Comments on the EIS for the Proposed Gas Pipeline from Young to Wellington.

I farm in the Billimari area. The proposed pipeline route crosses my farm on a soil type known to be highly erodible in an area of shallow groundwater.

FIGURE 9.1: PIPELINE RISK TRANSECT – ALL CASES

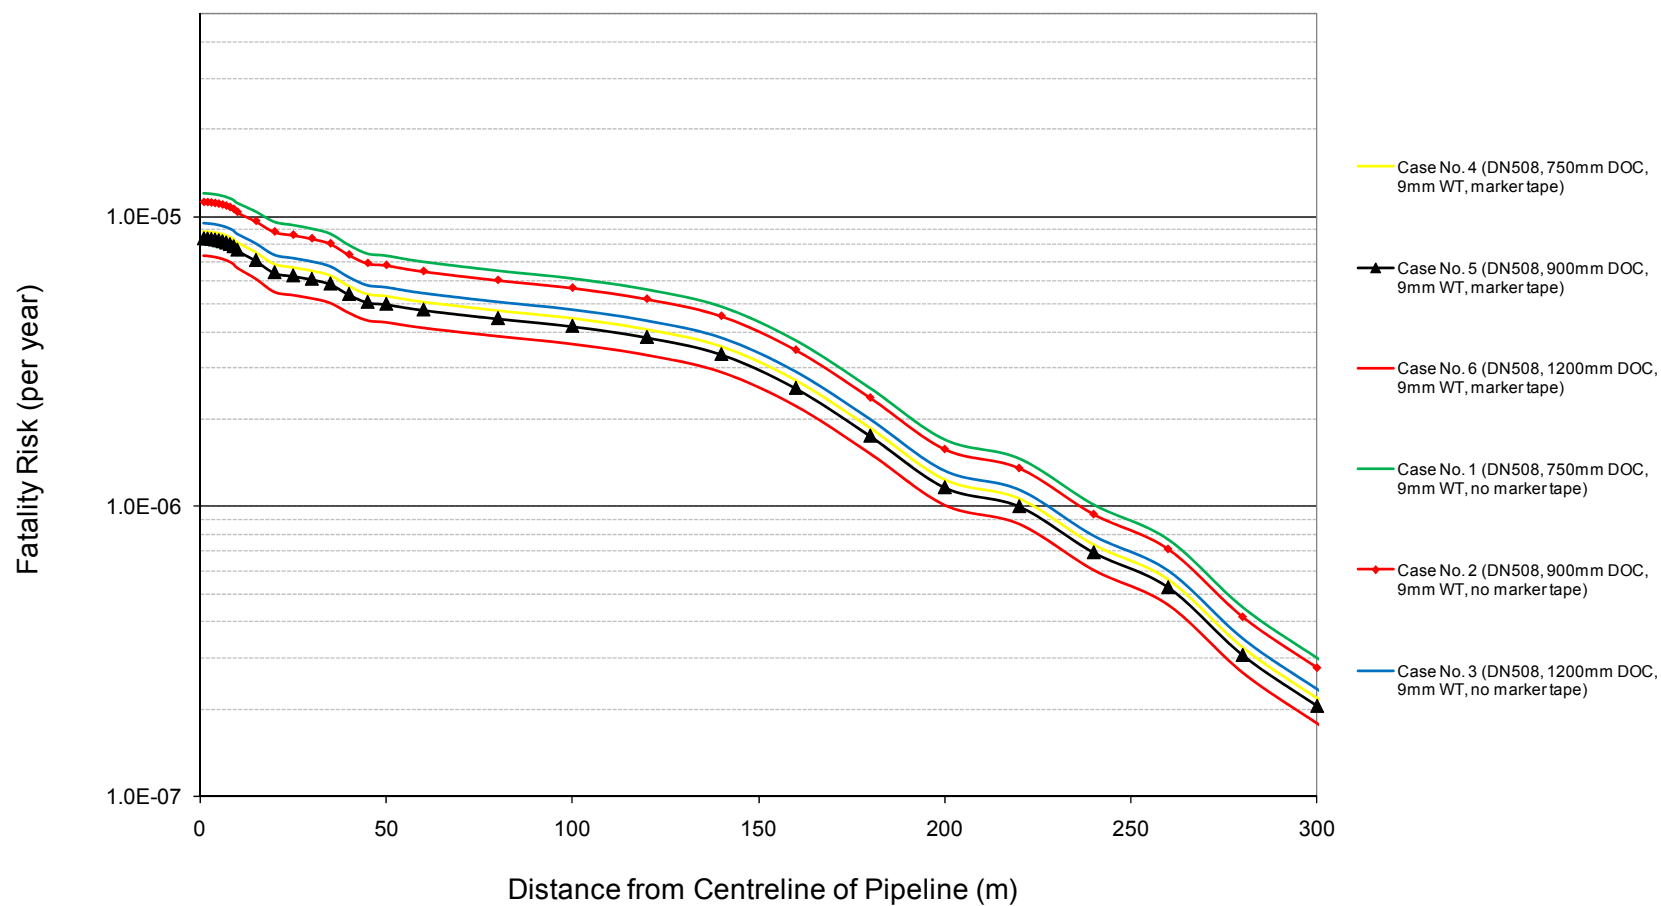
- By ignoring surface vegetation the fire hazard calculations underestimates the risk to householders in the surrounding dwellings and to those working on the surrounding farmland which should be considered a populated workplace. Grassland fires can travel extremely quickly and cause serious injury or death when people are caught by surprise.

- The speed and scale at which a fire would establish would remove the opportunity to control the fire quickly while it is still small. Over 90% of fires are contained quickly because control efforts have commenced when the fire front is less than 100m wide. The figures from ERM Power indicate that if a significant leak is ignited a fire front would establish a fire front of half a kilometre would establish in dry grass.

- The incident frequencies used in this study do not take in account agricultural practices such as percussion soil coring, deep ripping or driving strainer posts which are placed 1.2m deep.

- The marker tape provides no protection to the pipe from these operations. The traditional 200m markers are likely to suffer from farming operations as increased reliance on satellite controlled steering and wide machinery means manual avoidance of hazards is difficult.
